CITY OF ALBUQUERQUE

July 7, 2014

**Re: FedEx Ground Drainage Report and Conceptual Grading Plan and Drainage Plan
Engineer's Stamp Date 7-3-14 (K09D026A)**

**OVERALL GRADING
AND DRAINAGE PLAN**

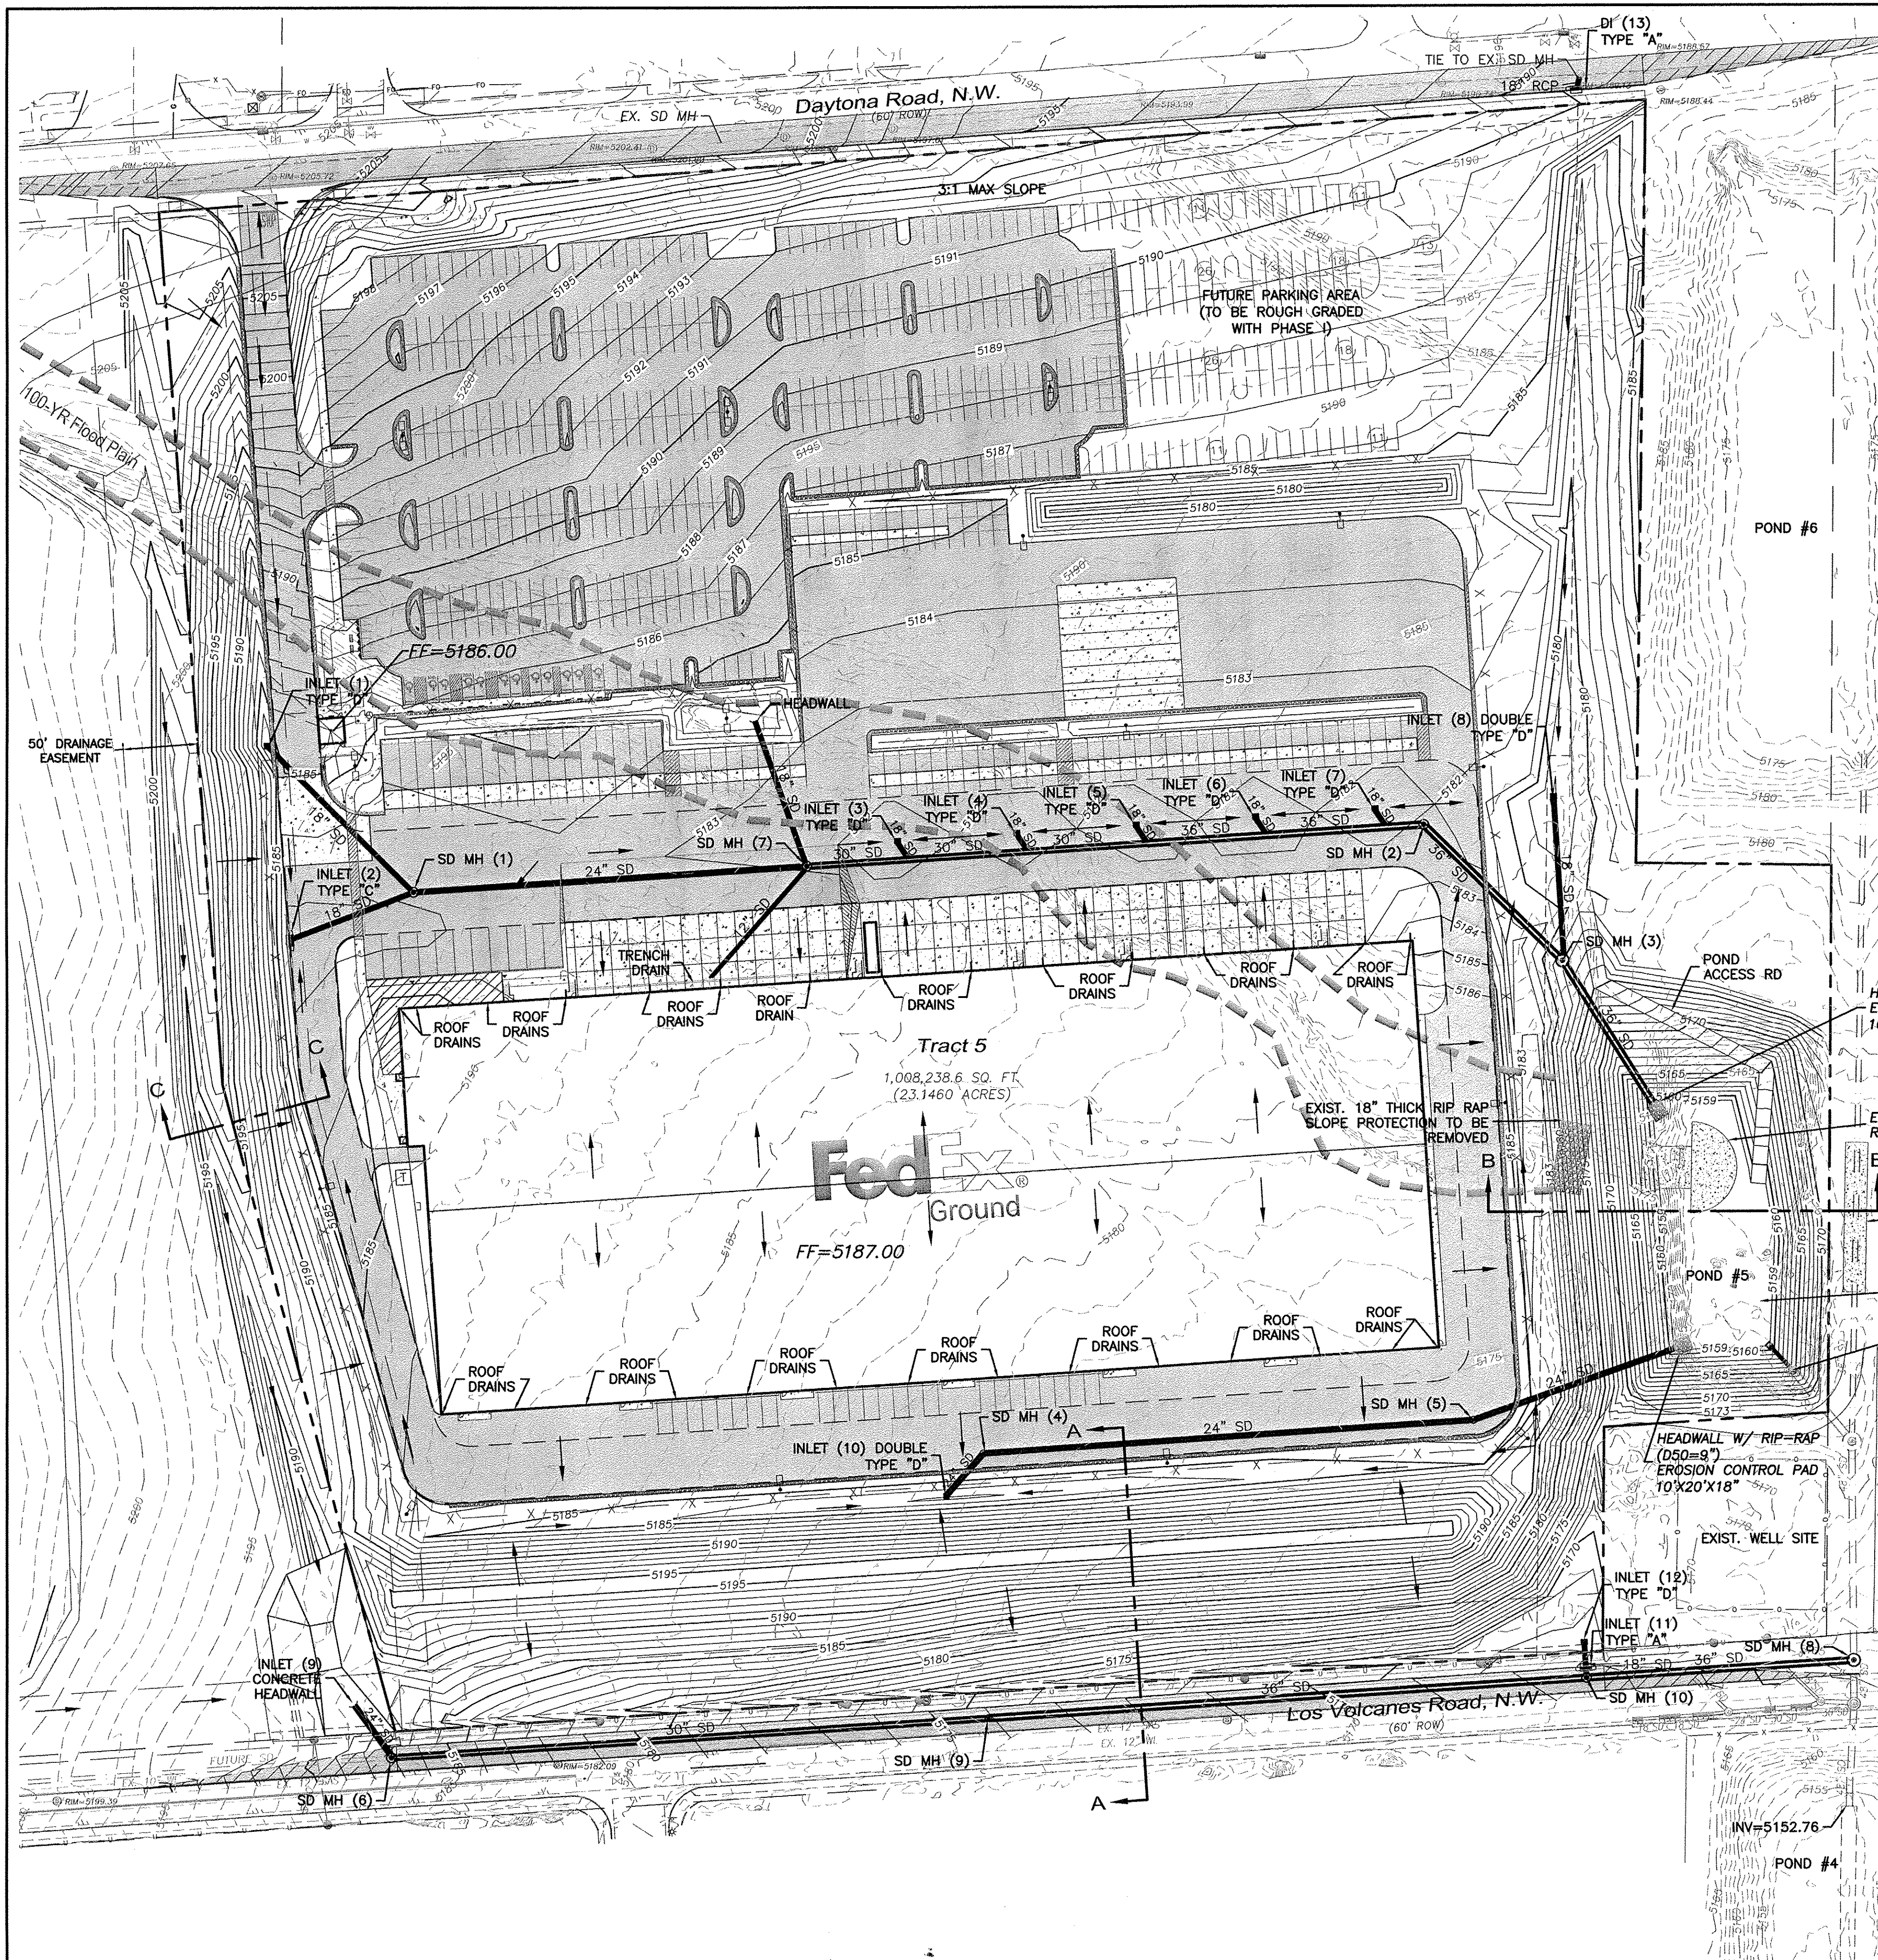
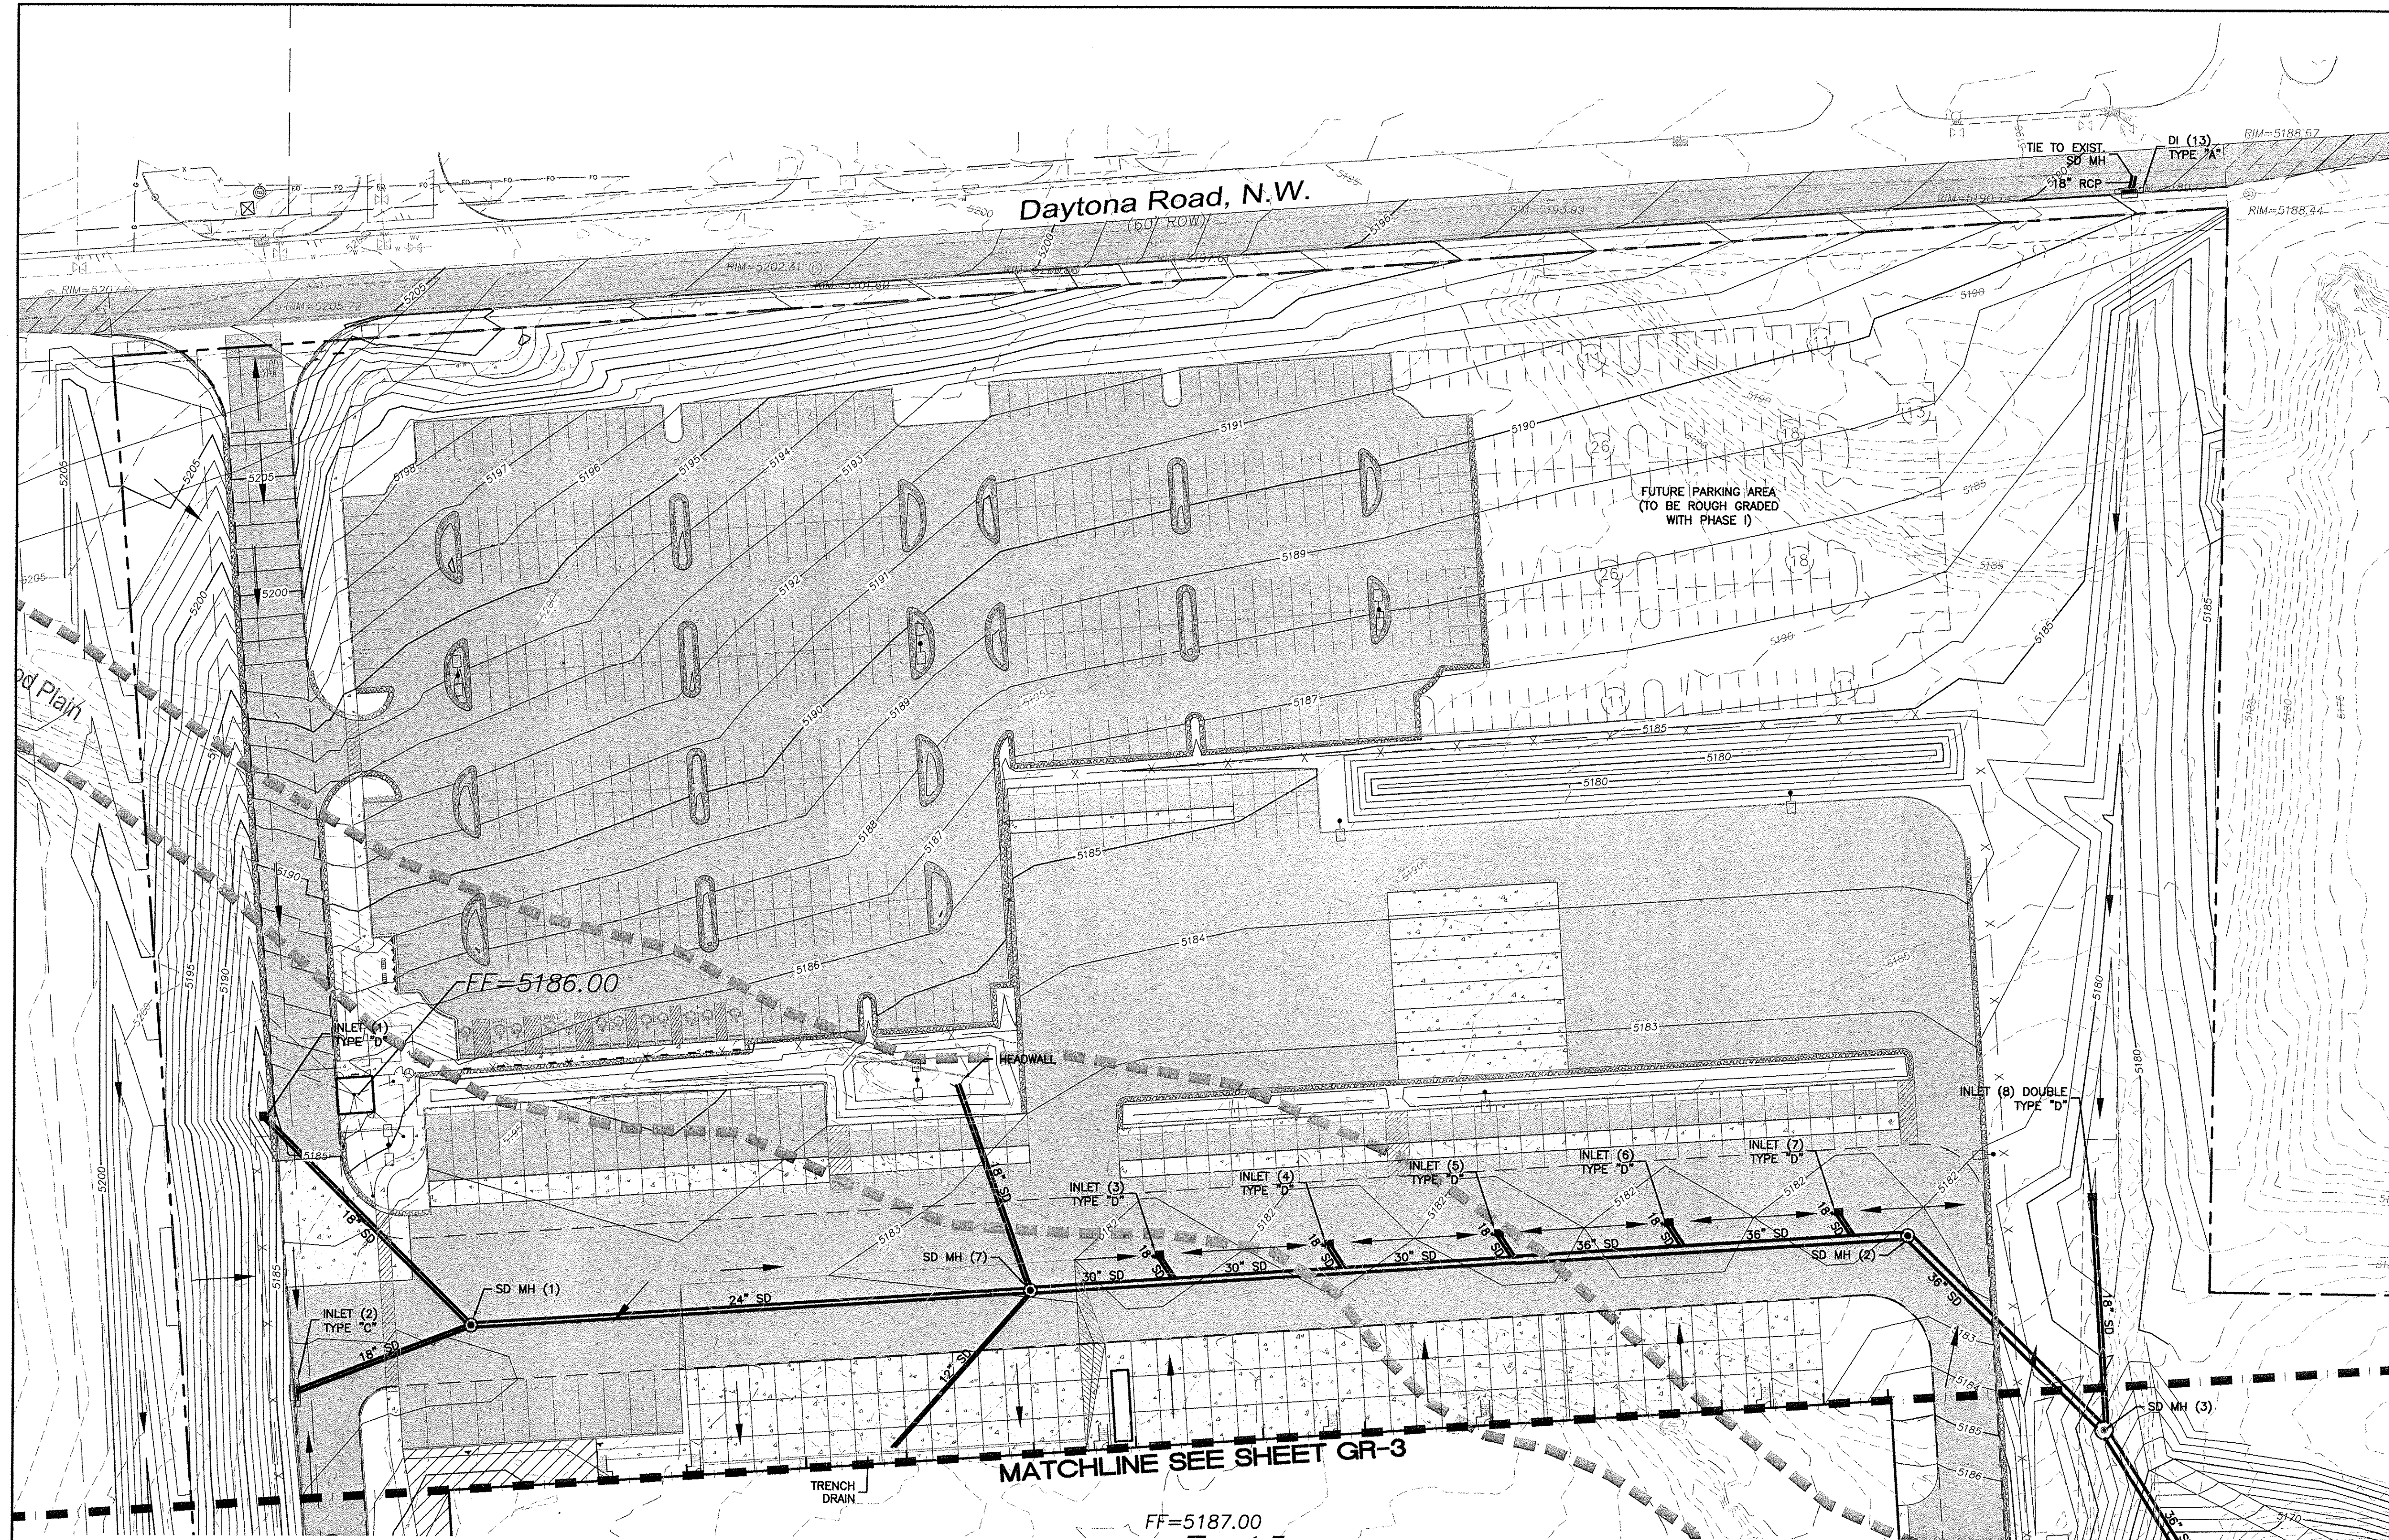
1. The berm at the edge of pavement should be removed as it is in the clear zone.

PO Box 1293 2. The sedimentation pond near Bruckner's should be proposed out of the ROW. The pond should be positioned so that the street can be constructed without having to change the proposed pond.
